# The Keadby 3 Low Carbon Gas Power Station Project

## Environmental Statement Volume II - Appendix 1B: Scoping Opinion

# **SCOPING OPINION:**

**Case Reference: EN010114**

Figure 2B

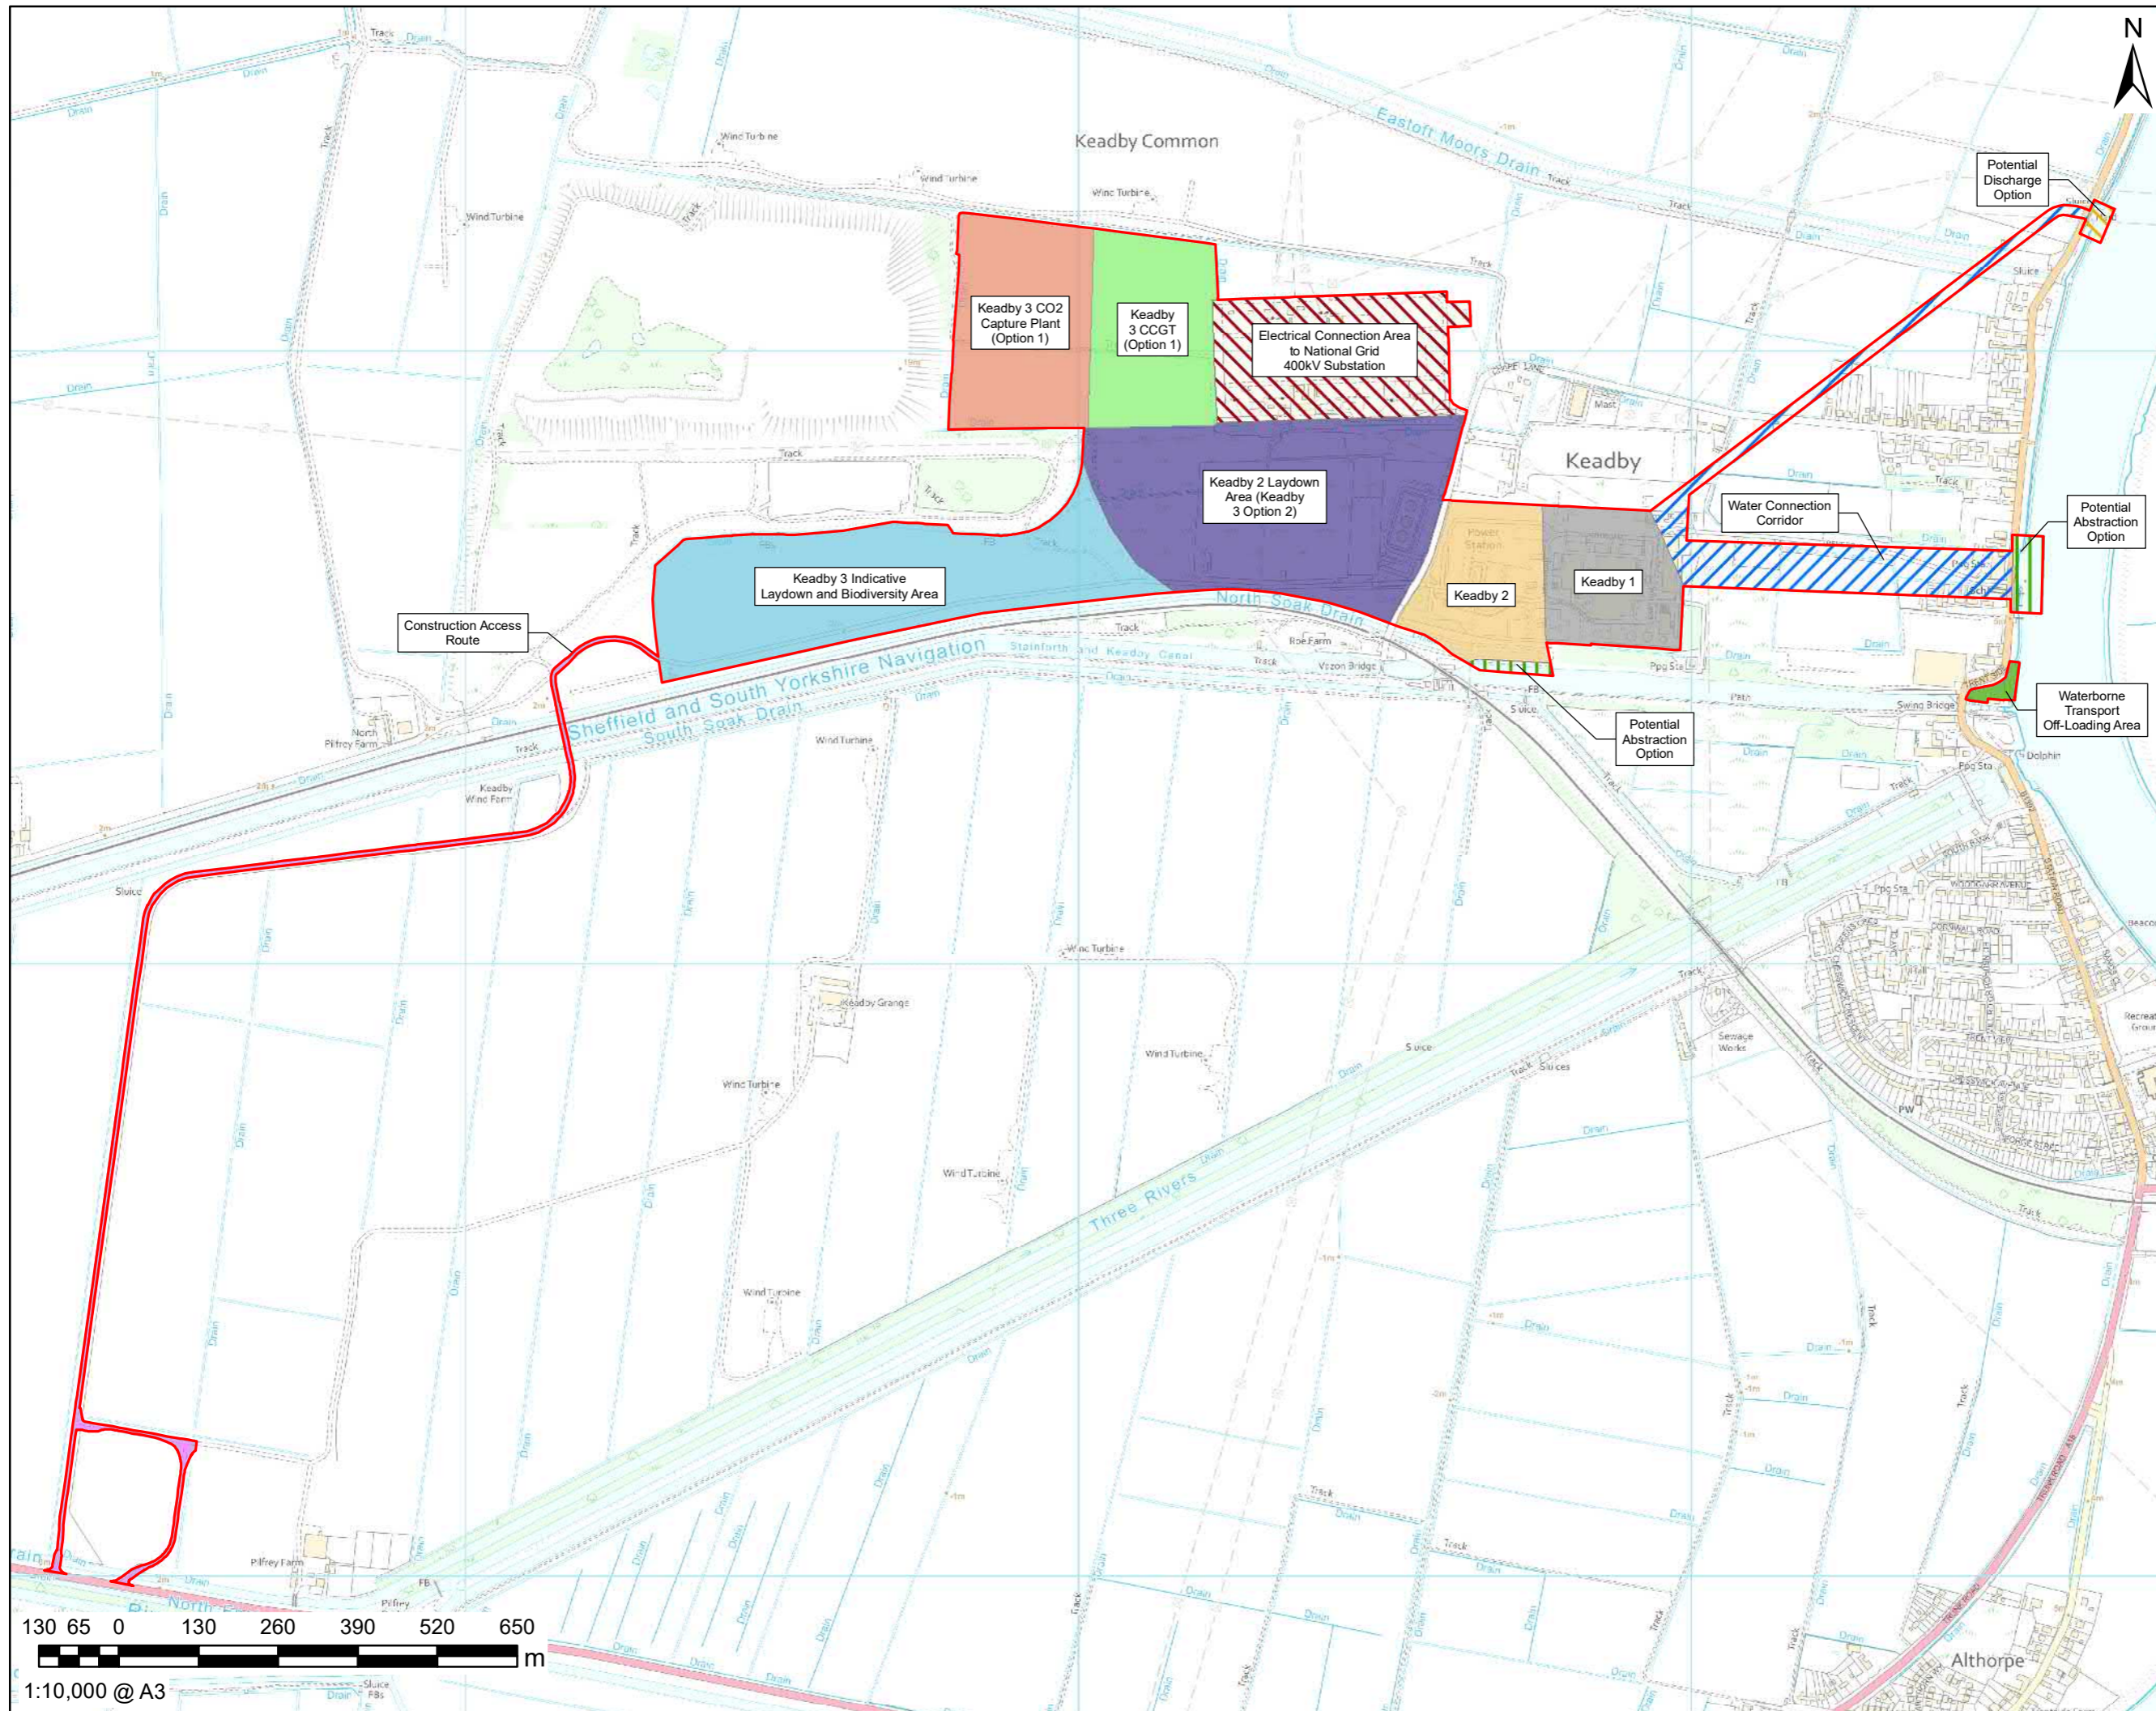
- 2.3.6 A large area is denoted on Figure 2B for the electrical connection to the existing substation. The figure does not denote where the gas connection options are. Paragraph 4.2 suggests that there are alternative options for both the gas and electricity network connections. The ES should provide greater clarity regarding the connections and effort should be made to refine the options and remove uncertainty. However, where uncertainty remains the assessment should be conducted in accordance with a worst-case scenario.
